Rezoning Transportation Analysis
Petition Number: Insert Zoning Petition #2021-017
General Location Identifier: Tax ID 08904208

Revision Log:	Date	Description
	02-25-21	First Review (EL)

RZ-1

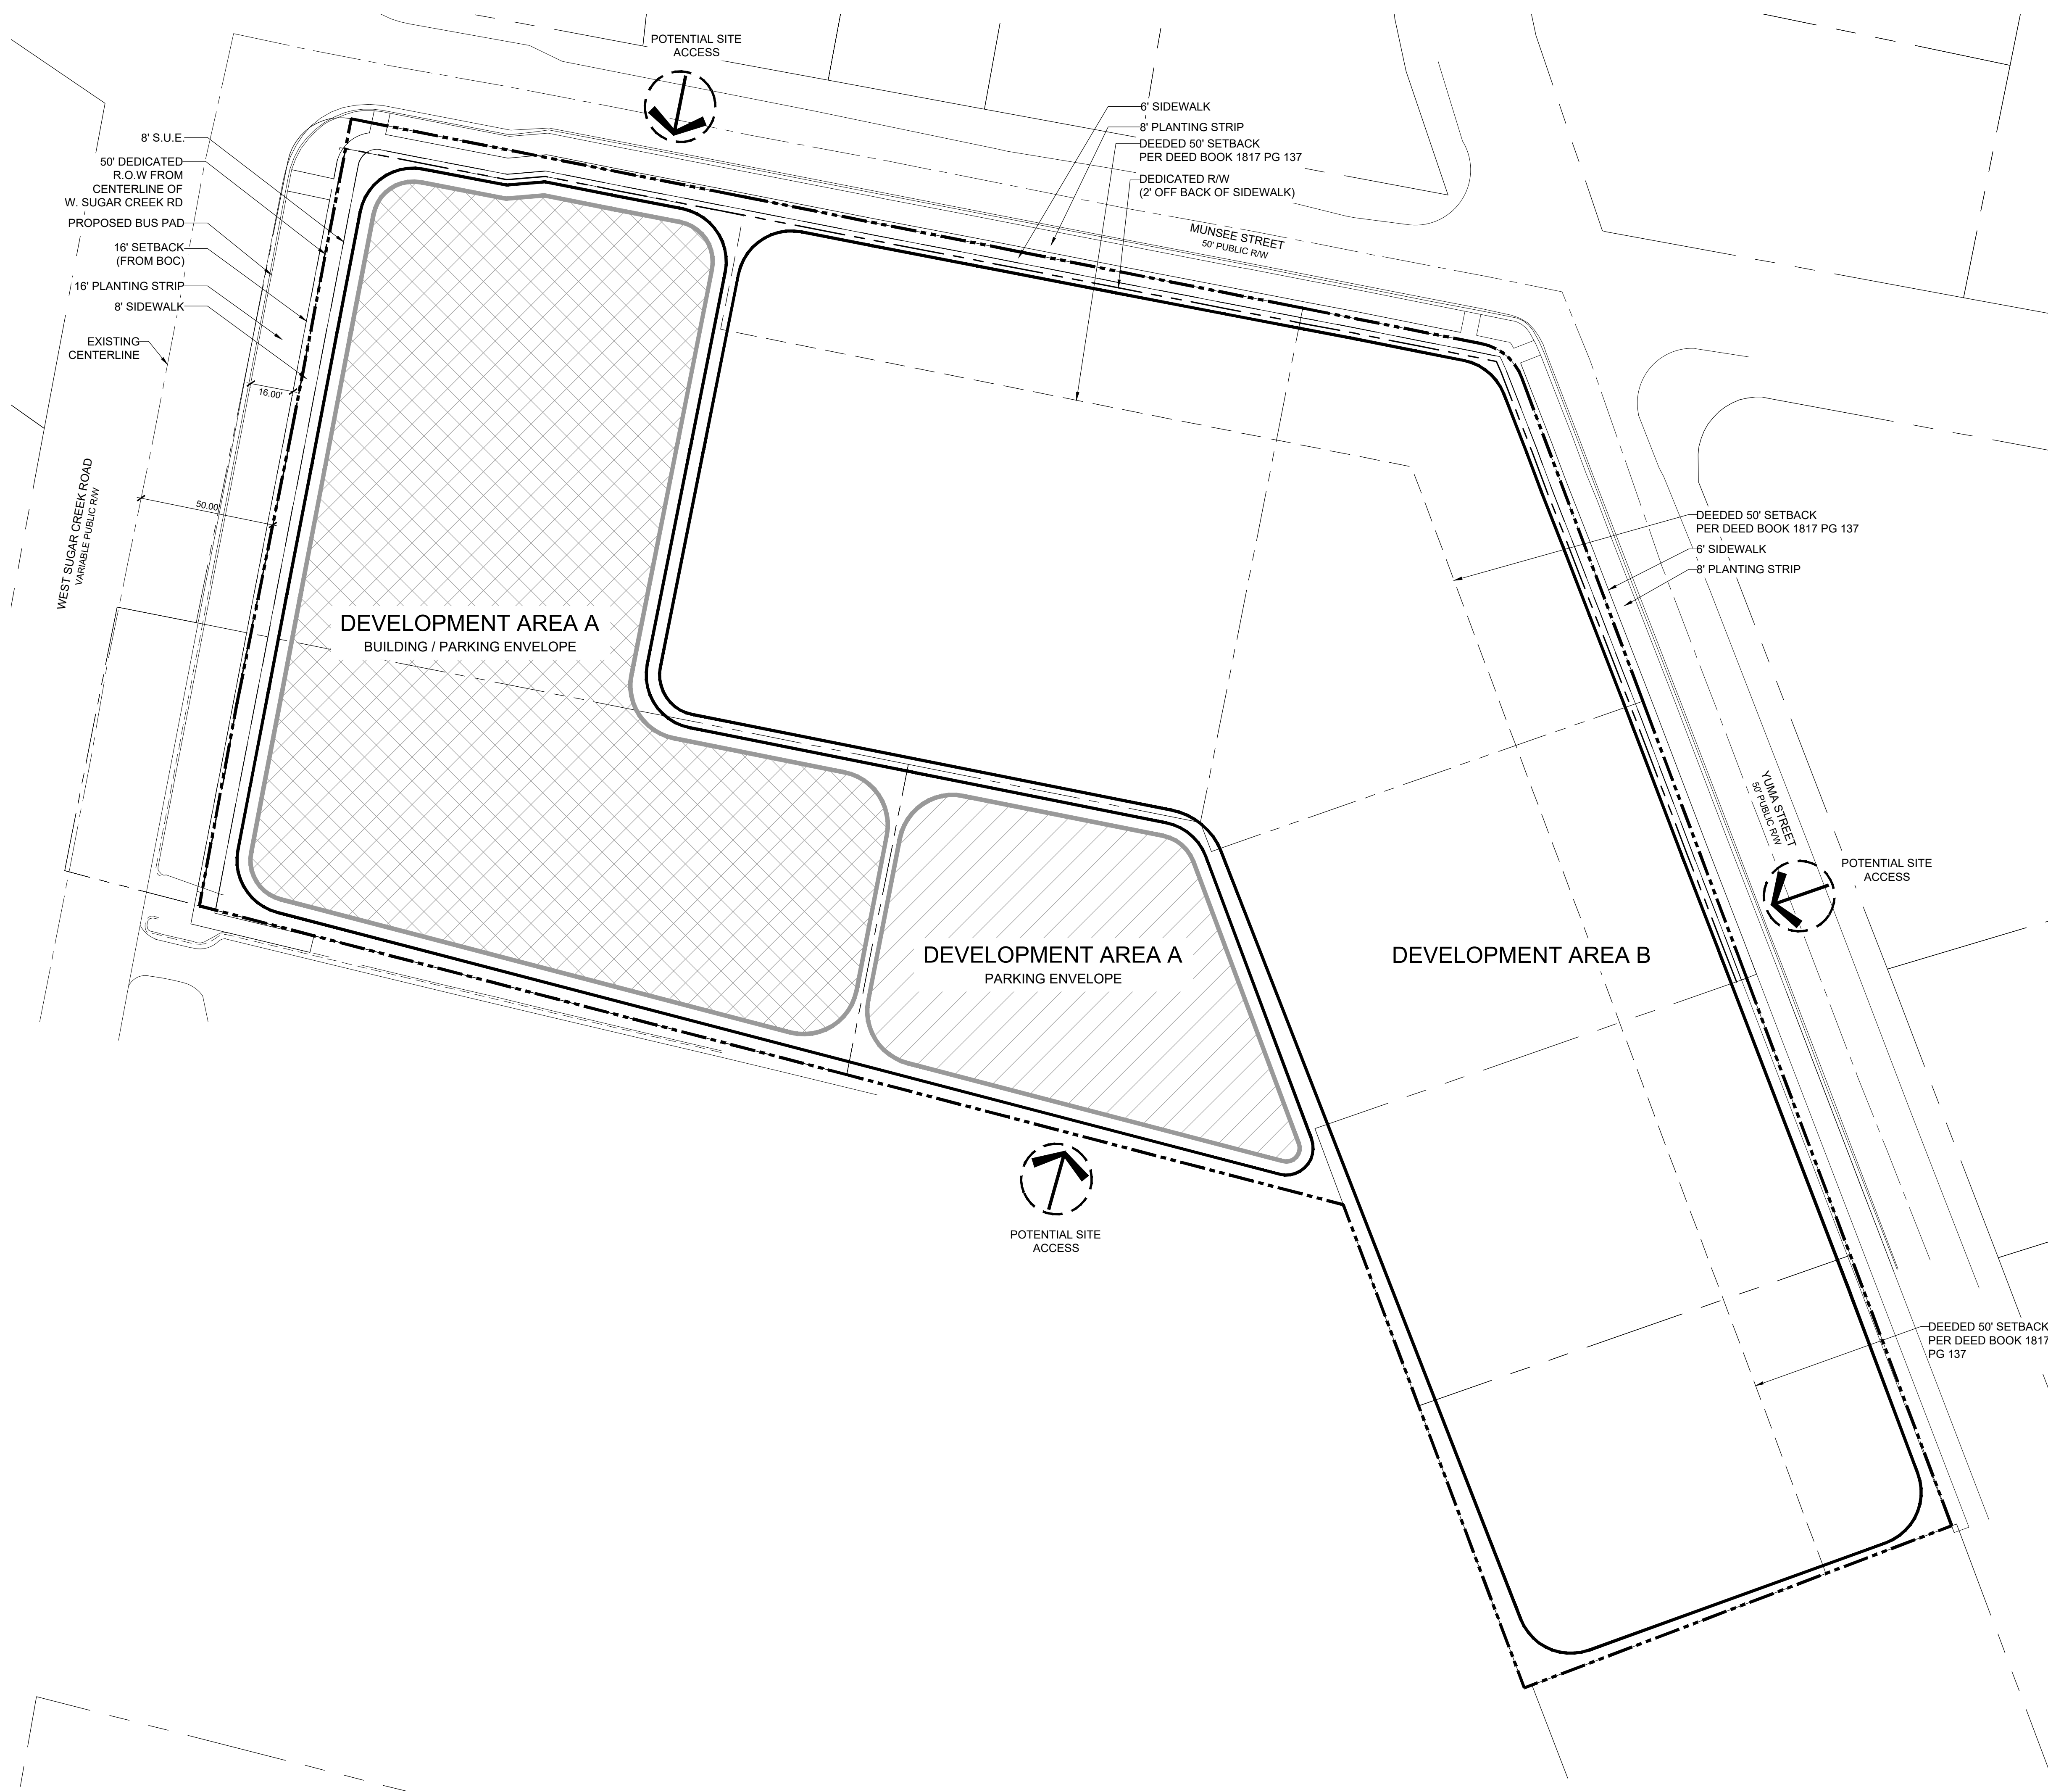
1. **Curbline:** The proposed zoning district has a setback measured from back of the existing or proposed future curbline.
 - a. **Sugar Creek Road:** Location of curb and gutter needs to be relocated to 41-feet from road centerline to back of future curb, to accommodate a future 4+ Boulevard road cross section with buffered/separated bike lanes, in accordance with Charlotte BIKES policy.

Label and dimension the curb and gutter from the centerline for each road on the site plan.

- b. **Munsee Street:** Replace the existing valley gutter for CLDSM standard curb and gutter at the existing edge-of-pavement along the rezoning property frontage.

- c. **Yuma Street:** Replace the existing valley gutter for CLDSM standard curb and gutter at the existing edge-of-pavement along the rezoning property frontage.

3. Revise site plan and conditional note (Section 4.d.) to commit to dedicate 57-feet of right-of-way from the Sugar Creek Road centerline, to accommodate a future 4+ Boulevard road cross section with buffered/separated bike lanes. Label and dimension the right-of-way from the road centerline.

4. The proposed dwelling units exceeds 12 per acre. Per Chapter 20: Subdivision Ordinance, site plan and conditional note(s) revisions are needed to commit to construct an 8-foot planting strip and 8-foot sidewalk along **all** public street road frontages; currently the site plan shows this for W Sugar Creek Rd only. The wider sidewalk also meets the Charlotte WALKS Policy.

5. Revisions are needed to revise conditional note (Section 4.f.) to clarify that two directional ADA ramps will be constructed at the corner of Munsee and Sugar Creek Road, in accordance with CLDSM and Public Right-of-Way Accessibility Guidelines (PROWAG), as correctly shown on the proposed site plan.

6. Site plan and conditional note(s) revisions are needed to revise conditional note (Section 4.a.) to provide a recorded access easement with the owner of **PID (08904203)**.
